Rezoning Transportation Analysis

Petition Number: 2021-186

Date	Description
12-28-21	First Review (TNM)

REZONING - SITE PLAN
THE VILLAGES AT GOVERNOR HUNT
 9405 MALLARD CREEK RD., CHARLOTTE, NC

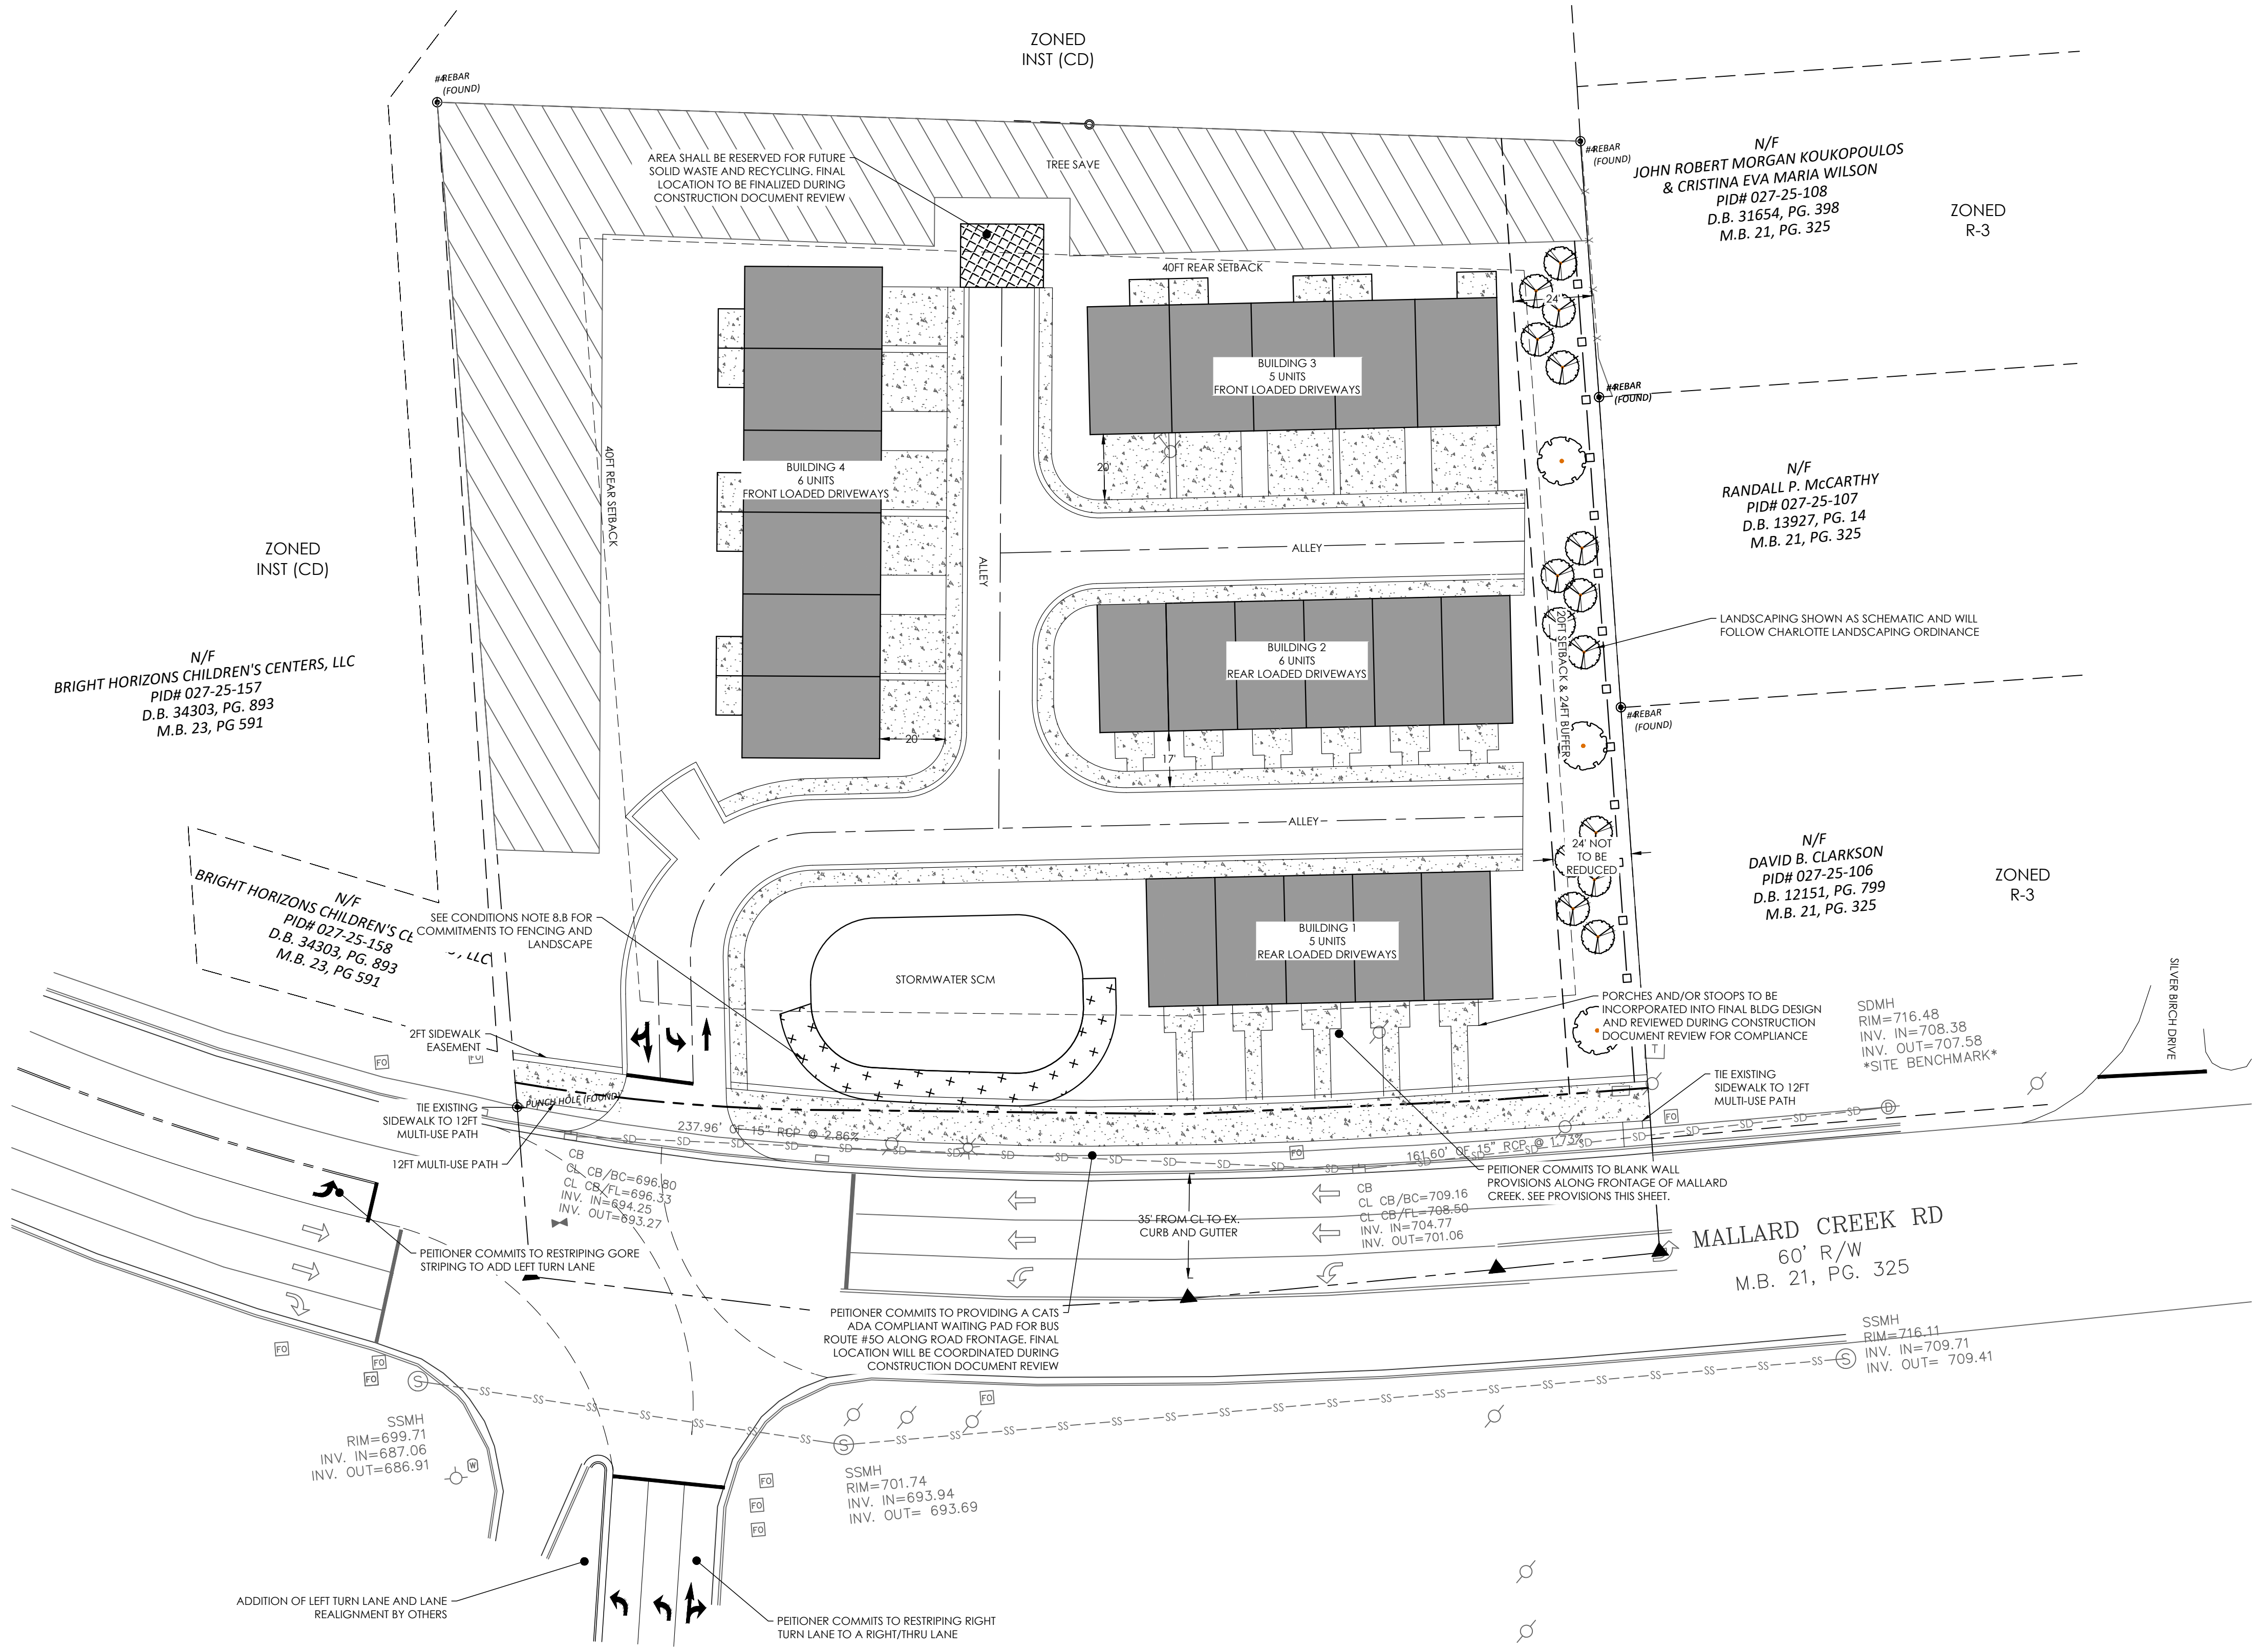
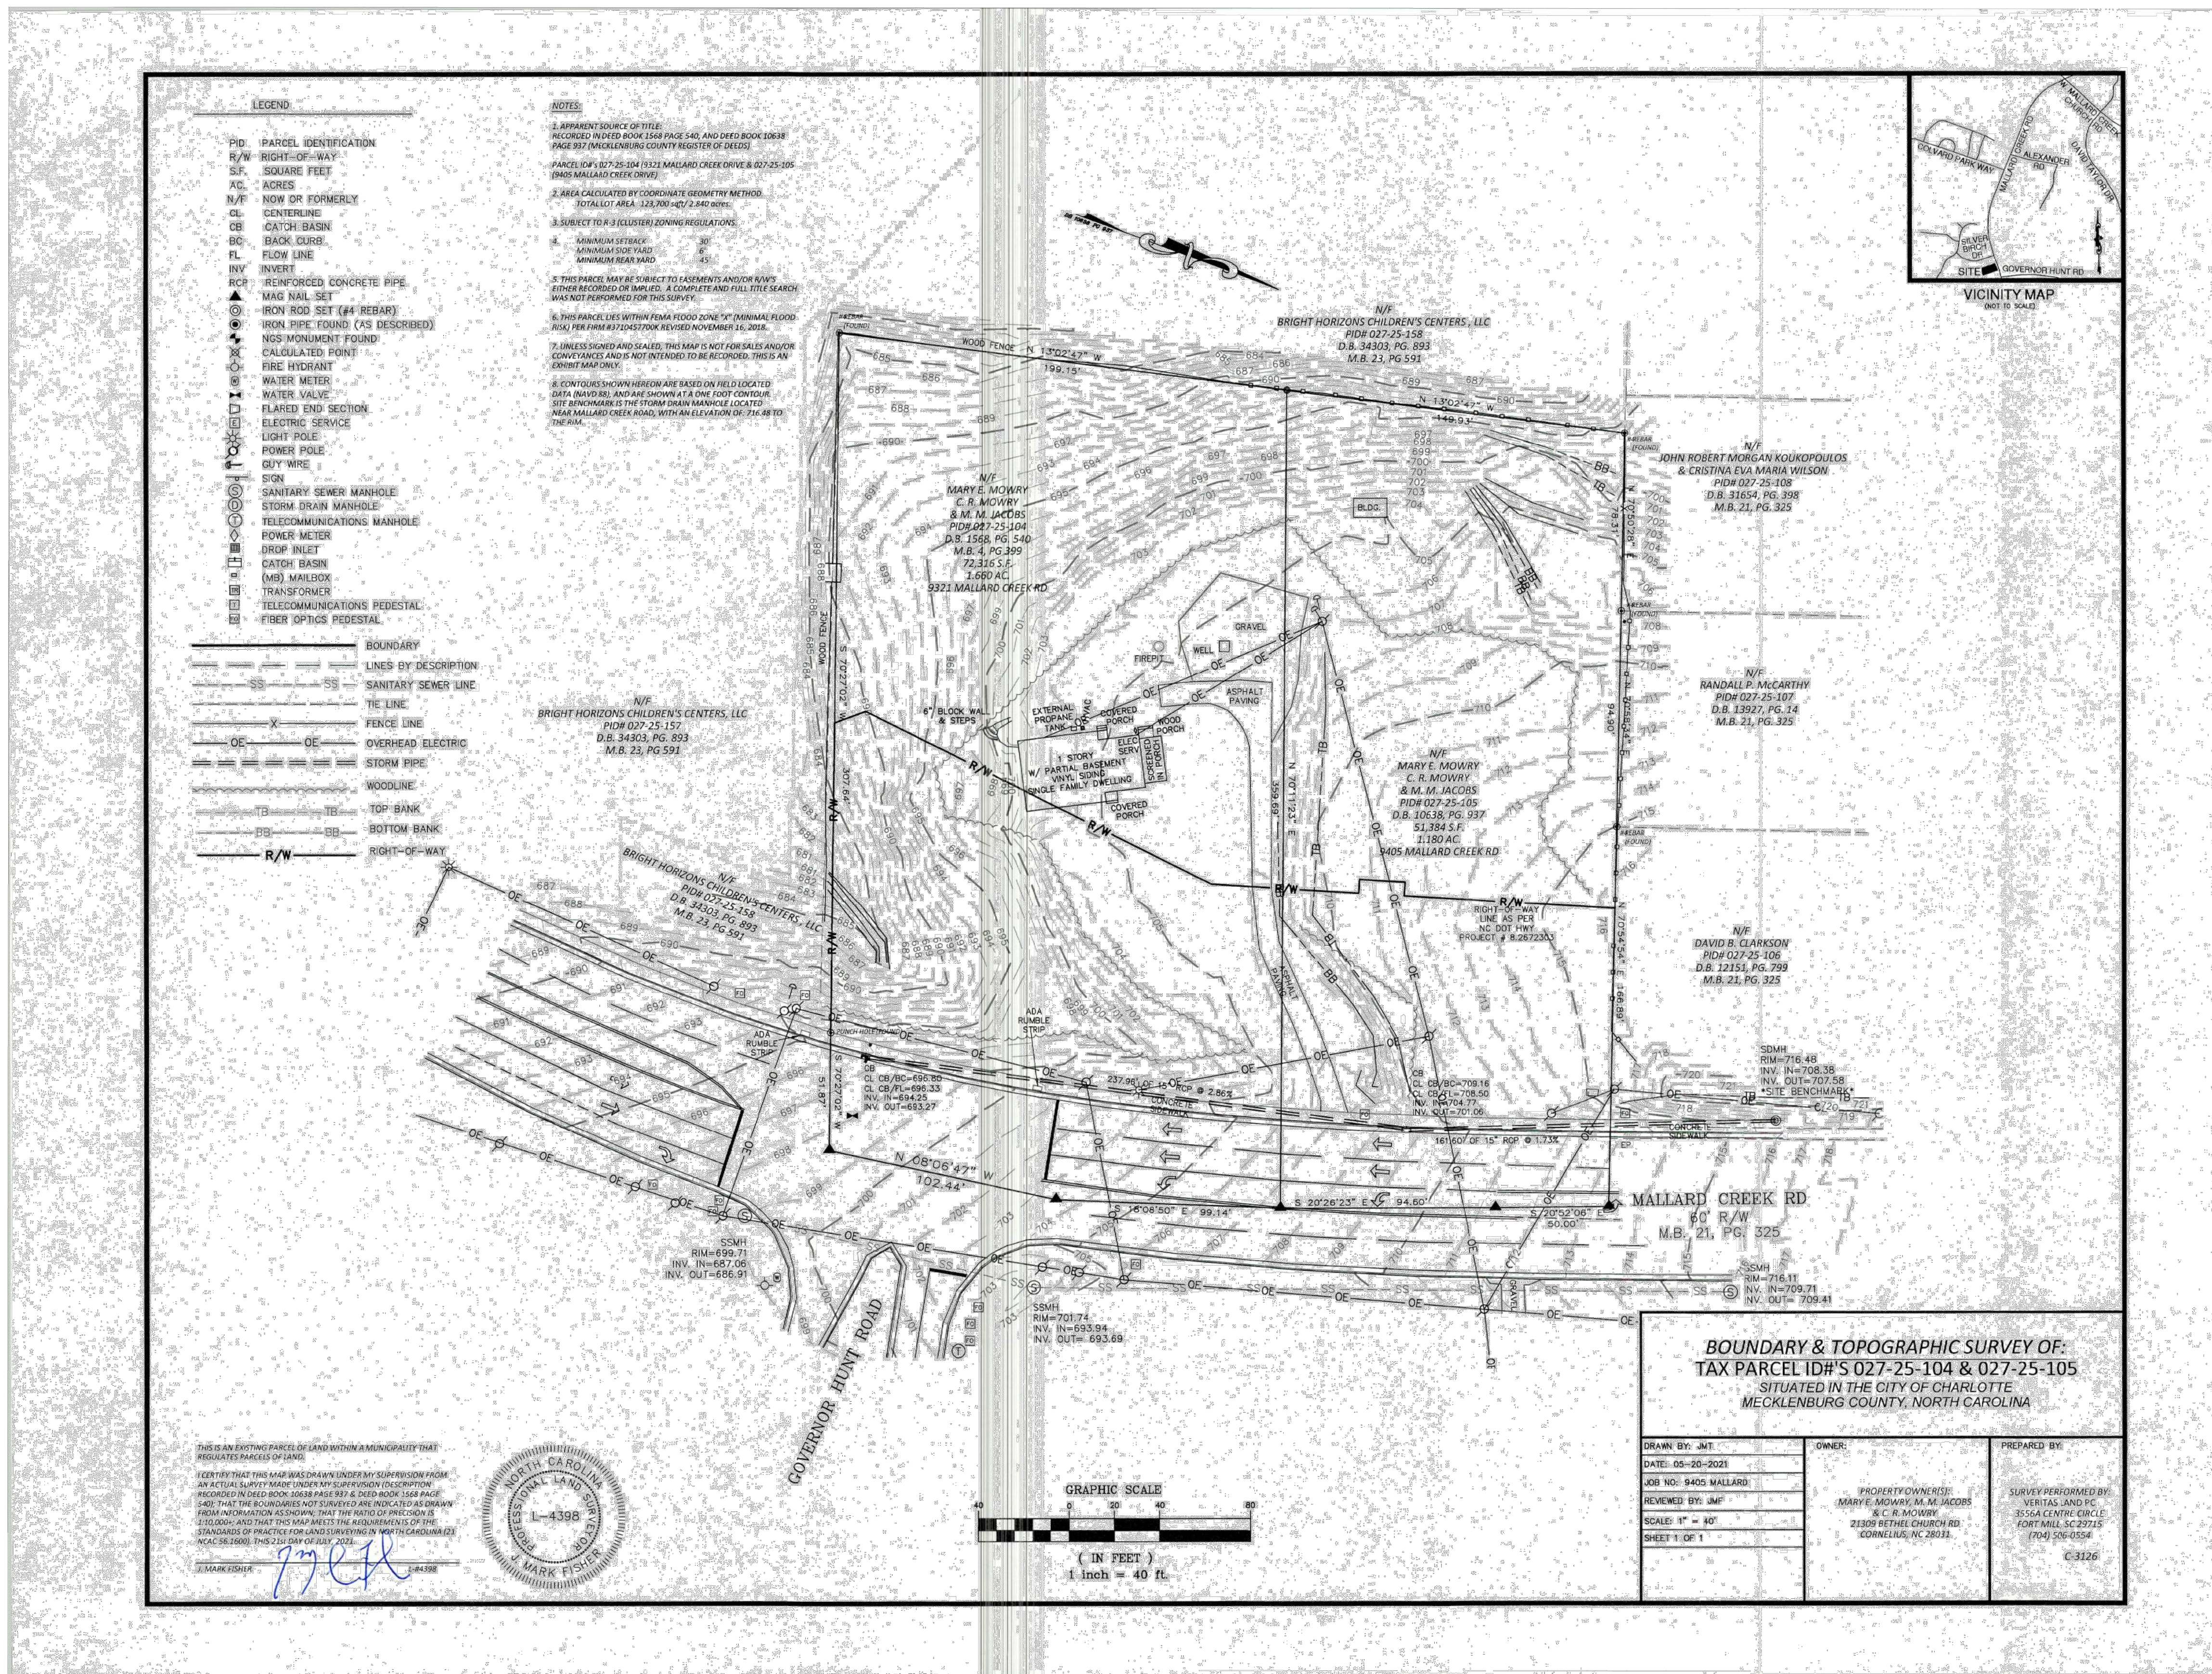
Label and dimension the curb and gutter from the centerline for each road on the site plan.

- Revise site plan and conditional note(s) to commit to dedicate 50-feet of right-of-way from the road centerline in accordance with Chapter 20 of the City's Subdivision Ordinance. The site plan shall label and dimension the right-of-way from the road centerline.

4. Revise site plan and conditional notes to commit to installing a concrete median along Mallard Creek Road to restrict the site driveway access to right-in / right-out. The median will be constructed from the intersection of Mallard Creek Road and Governor Hunt Road and extend 50 feet past the site driveway. The median will be designed to provide 150-feet of full width storage for the southbound left turn lane on Mallard Creek Road at Governor Hunt Road. Remove the proposed pork chop median at the site driveway.

5. Revise site plan to show the driveway radius tie into the existing curb and gutter at a tangent and ensure the driveway radius tie in point remains on the property.

6. Revise site plan and conditional notes to commit to construct an 8-foot planting strip, and a 12-foot multi-use path along the site's frontage of Mallard Creek Road per Chapter 19. The site plan shall label and dimension both items from the back of curb and road centerline. The 12-foot multi-use path also meets the council adopted Charlotte WALKS and Charlotte BIKES policies.

7. Revise site plan to label the proposed roads on site as private alleys.
8. Revise site plan to show the trash collection location for the site.
9. Revise conditional note 3.D. to specify dedication and fee simple conveyance of all rights-of-way to the City before the site's first building certificate of occupancy is issued. CDOT requests rights-of-way set at 2' behind back of sidewalk where feasible.
